7 July 2014

**State Significant Development Application – Station Site South and Station Site North**

## Station North and Station South Site - State Significant Development Application

Figure 12 – SSDA Station Street design

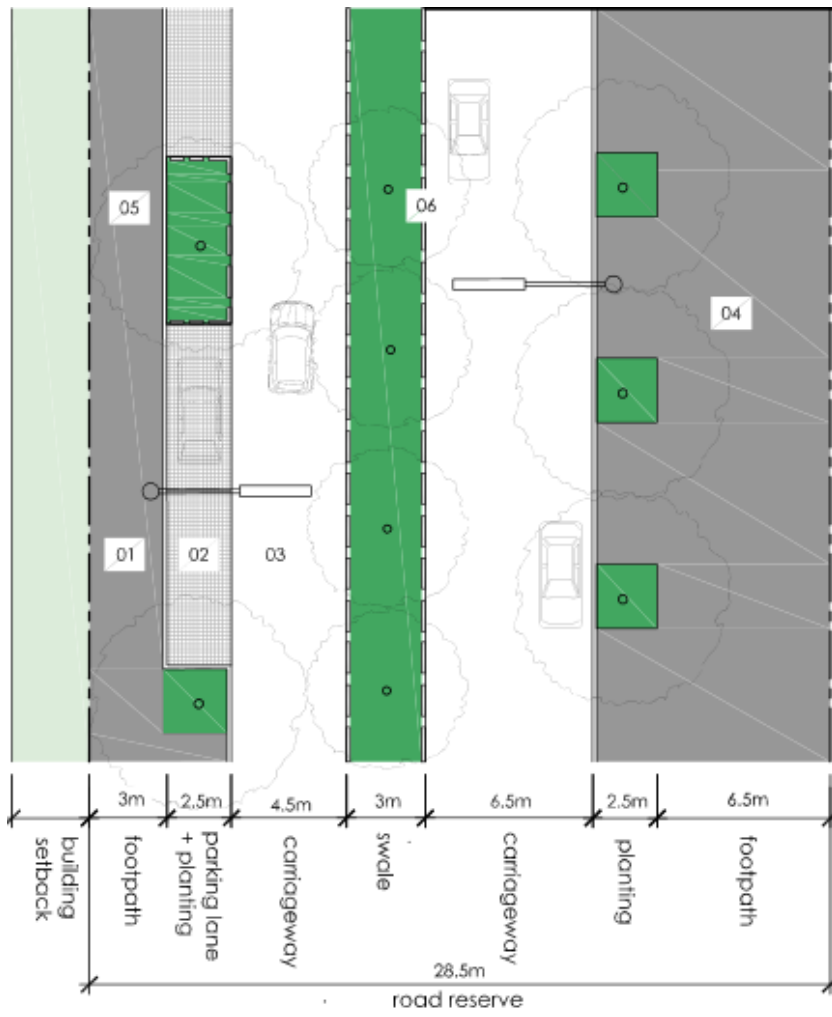
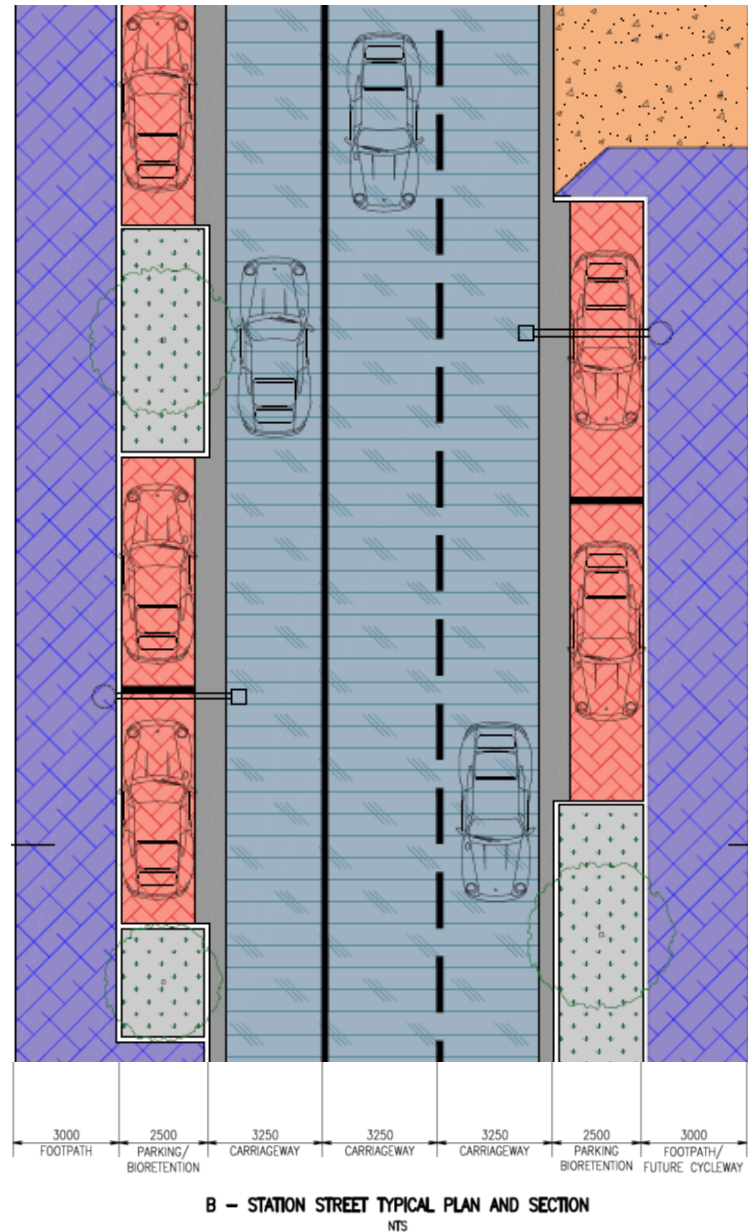
The proposed road design of Station Street fails to comply with the road design detailed within the DCP. The DCP controls provided at Section 4.1 Streets require Station Street to be a minimum width of 28.5m. The proposed design seeks to reduce this to 20.75m, resulting in a total reduction of 7.75m. This reduction is the result of:

- Removal of the 3m swale in the centre of the street
- Reduced vehicle carriageway width from 4.5m to 3.25m
- Reduced footpath width from 6.5m to 3m.

The proposed reduction in width is not supported. The reduction of the proposed footpath width is not considered appropriate as the NRSUAP has been predicated on non-car transport options such as cycling, walking and public transport. In this respect, to provide a positive pedestrian environment around the station, footpath widths should be as generous as possible. Furthermore, it is noted that the Station North Site will be developed in the near future and adaptability should be built into the infrastructure through generous footpaths to ensure that access to the station can be achieved from Station Street. The prioritisation of pedestrians as identified in the Parsons Brinckerhoff study can only be achieved where reasonable and appropriate footpaths are provided.

With regards to the deletion of the swale, Council's stormwater engineers have not identified any issues with this on stormwater grounds. However, with regards to traffic movements, the swale would have prevented u-turning within Station Street. Alternate treatment methods such as a median strip may be required to prevent U-turns. This is of particular concern given that the proposed shared way has not been designed to allow for vehicle passing. It must also be considered whether the prevention of right turns into the vehicle entrance to Station Site North is required. The deletion of the swale results in the removal of street tree planting and vegetation which significantly changes the character of Station Street. It is noted that the Transport Impact Assessment identifies that this planting has been recovered elsewhere in the NRSP but that this has yet to be detailed. This potential loss of greenery should be avoided.

Title
SWEEP PATH ANALYSIS PLAN
Project
**NORTH RYDE STATION SITE NORTH
DEVELOPMENT APPROVAL**

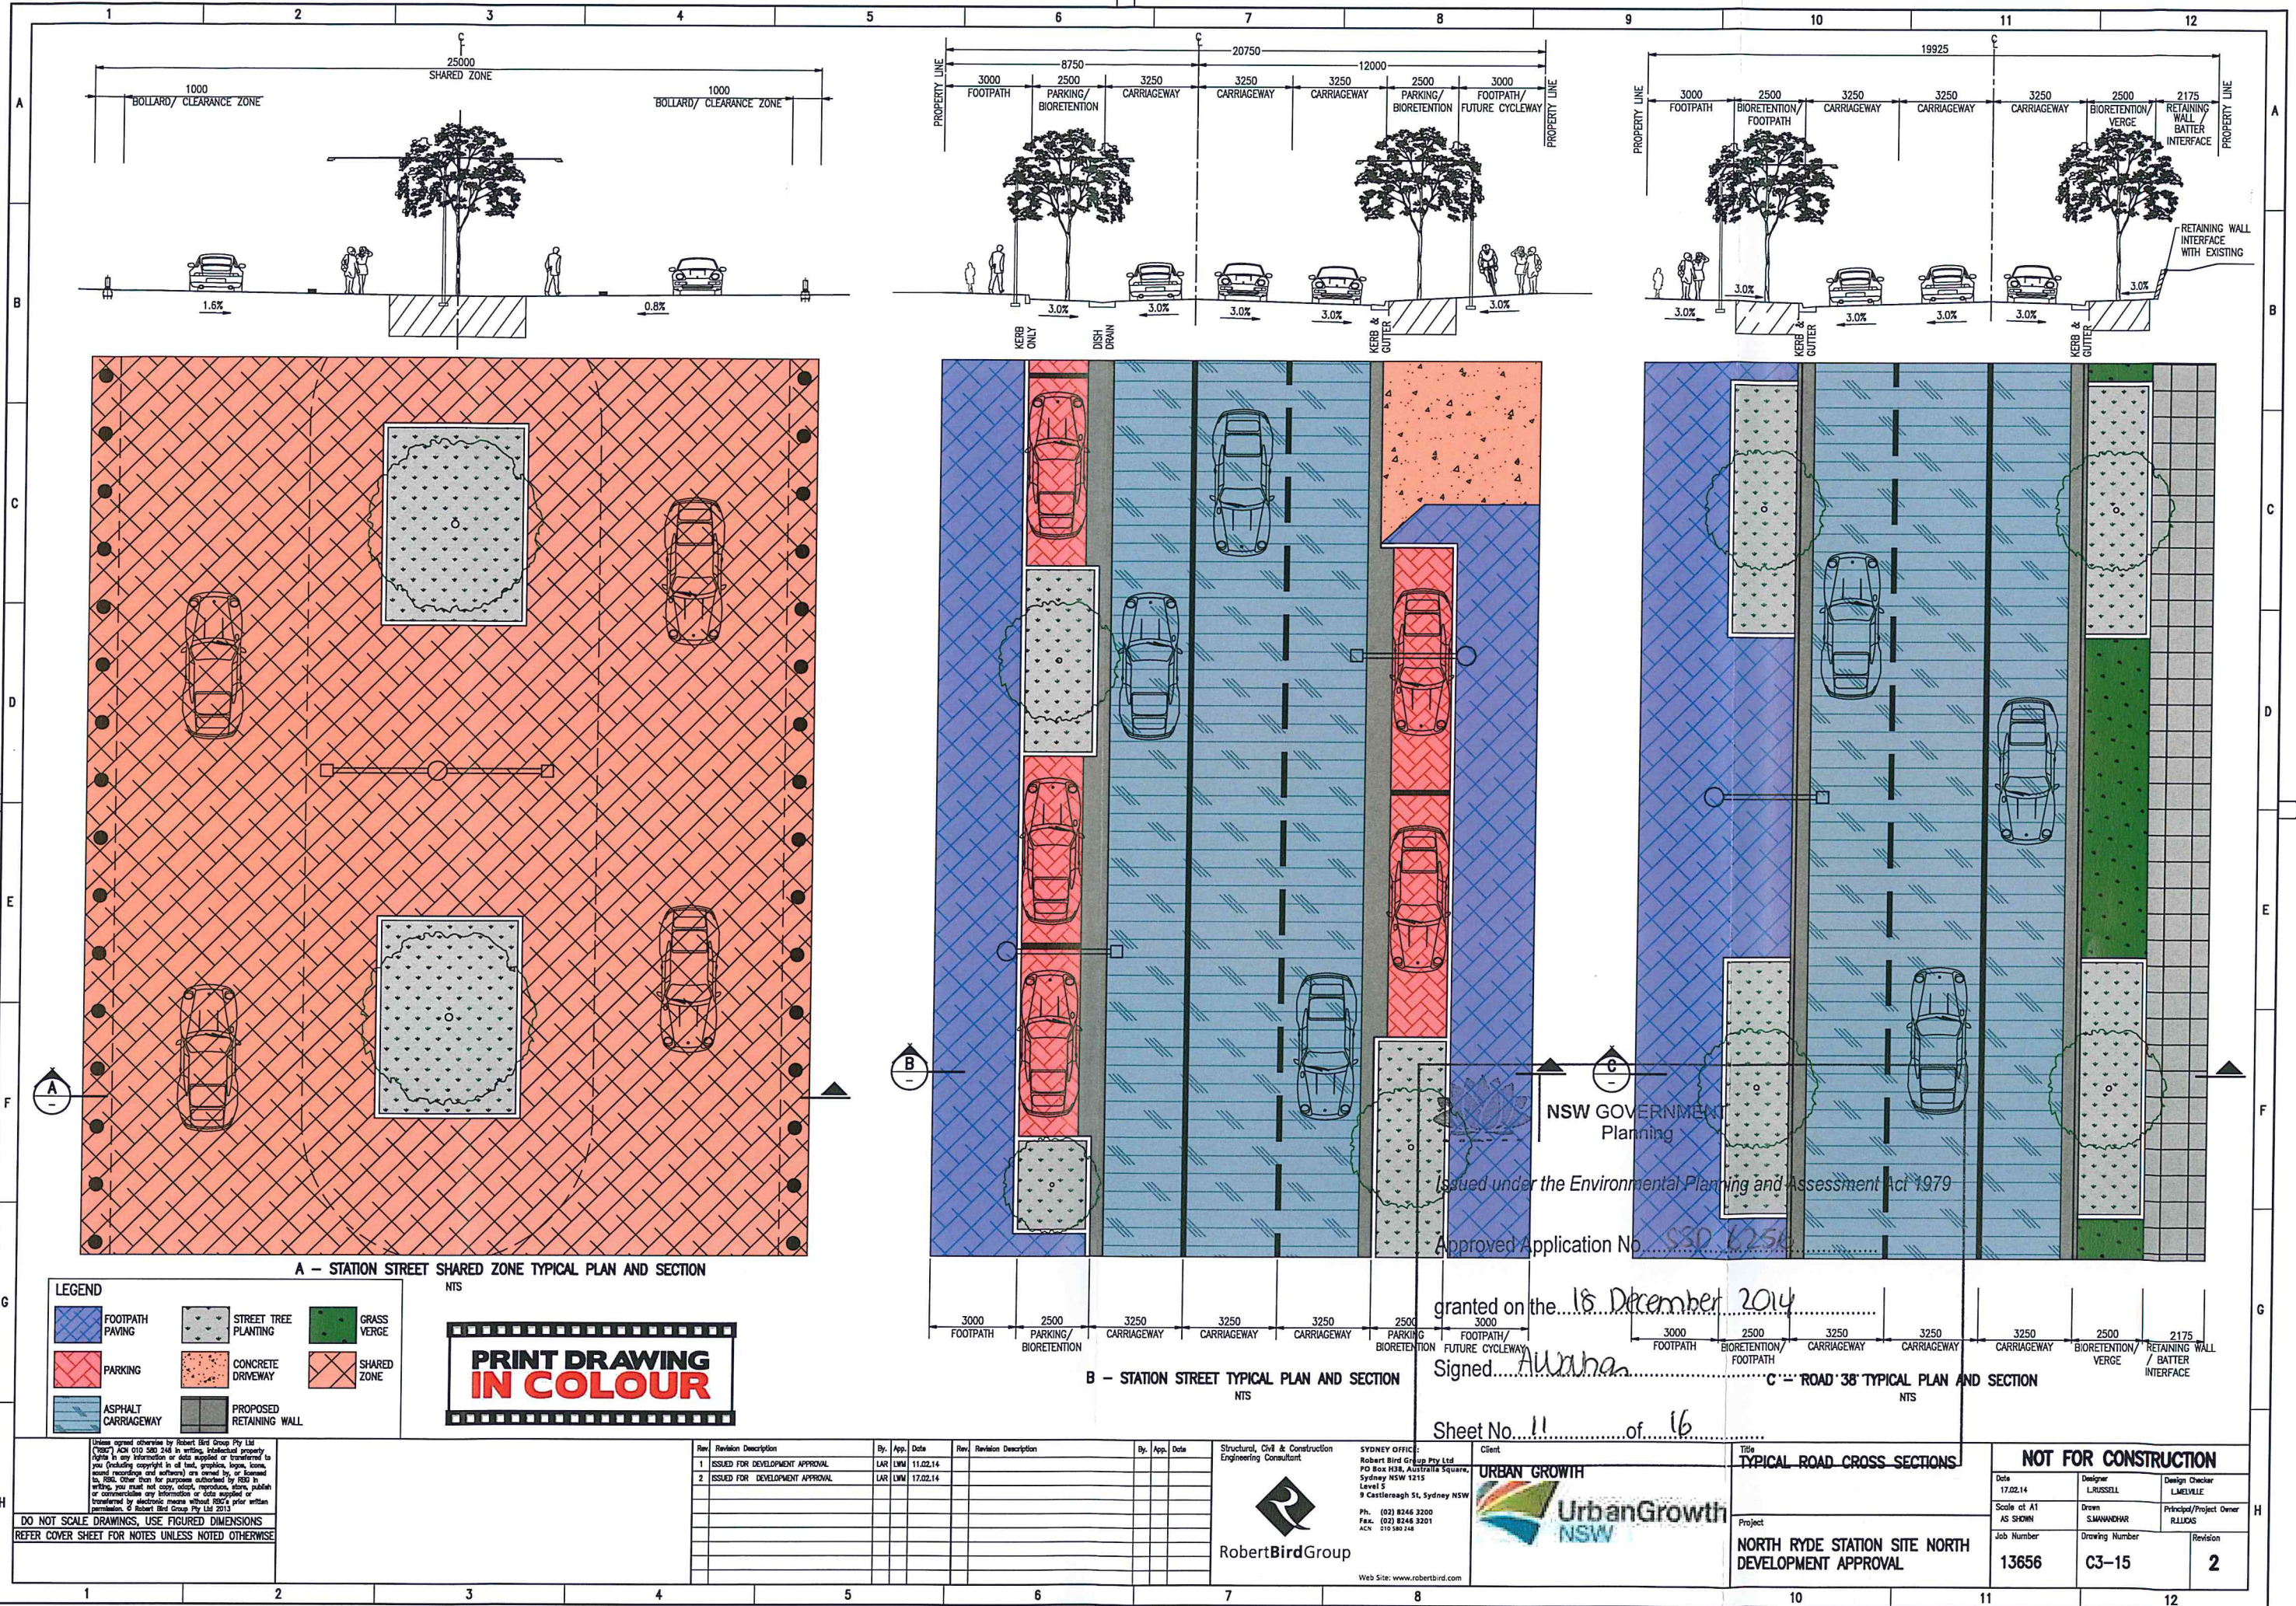
With regards to the proposed shared way and the submitted Signage Plan, it is considered that additional entry signage for the Shared Zone is required. Furthermore, the signage should be coordinated with the proposed MFPs as identified in the attached Lighting Plan. Any proposed signage plans would need to be considered by the Traffic Committee. The updated signage plan can be reviewed by Traffic Committee on 31 July 2014, however this would need to be provided to Council by 16 July 2014. Additionally, given that the submitted plans have identified a singular vehicle entry point for the Station Site North, the shared zone must allow for access by Council's Waste Truck. Should the Department not support the request of Transport for NSW to widen the turning head to 20m, a swept path analysis for a medium rigid vehicle (9.8m truck) must be provided.

In addition to the above, it is noted that the swept path analysis indicates that there will not be sufficient space for vehicles to pass one another in the same direction along Station Street. This is of significant concern given that this area is likely to be used for drop-off/pick-ups which may require some waiting time. It must also consider what will occur should a vehicle breakdown within the shared way. It is also noted that the 1/6 ramp grade will not comply with current design practices with respect to ramp face grades on a raised threshold area for pedestrian use (refer to RMS technical direction TDT 2001/04a).
